Our ref: K/24/11/NMA

**Application for a non-material amendment following a grant of planning permission K/15/11/ to modify existing dormer structure to south elevation, adjust roof to accommodate additional/deeper fenestration.**  
**55 Coastal Road, East Preston**

SOUTH ELEVATION

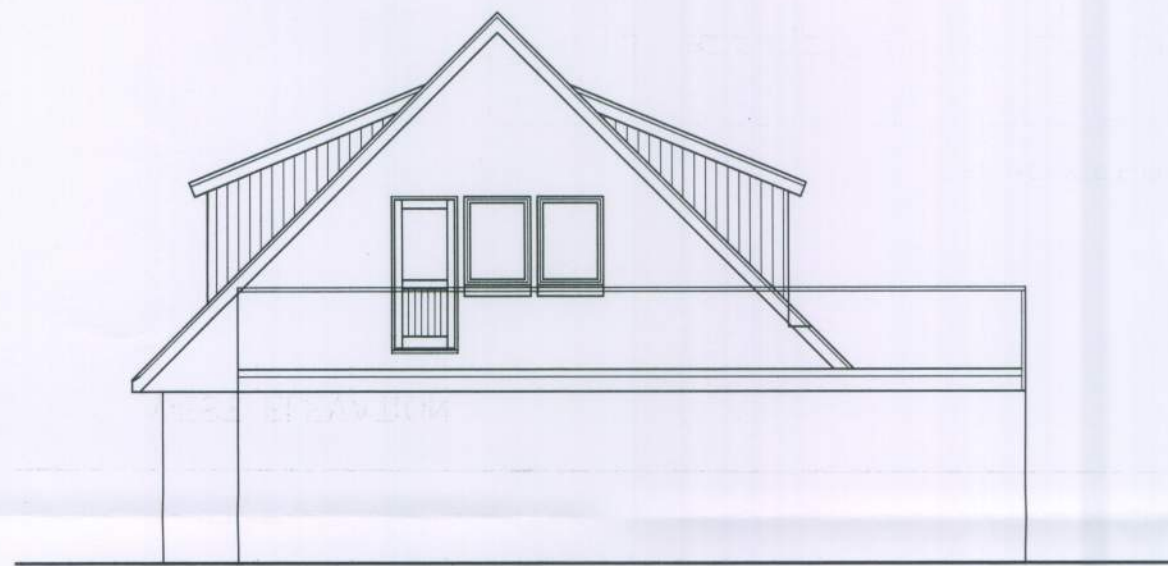
The changes identified within Drawing No. 03P from the approved plan, namely the reduction in height of the proposed southern dormer will be accepted as Non Material Amendment to the previous planning approval.
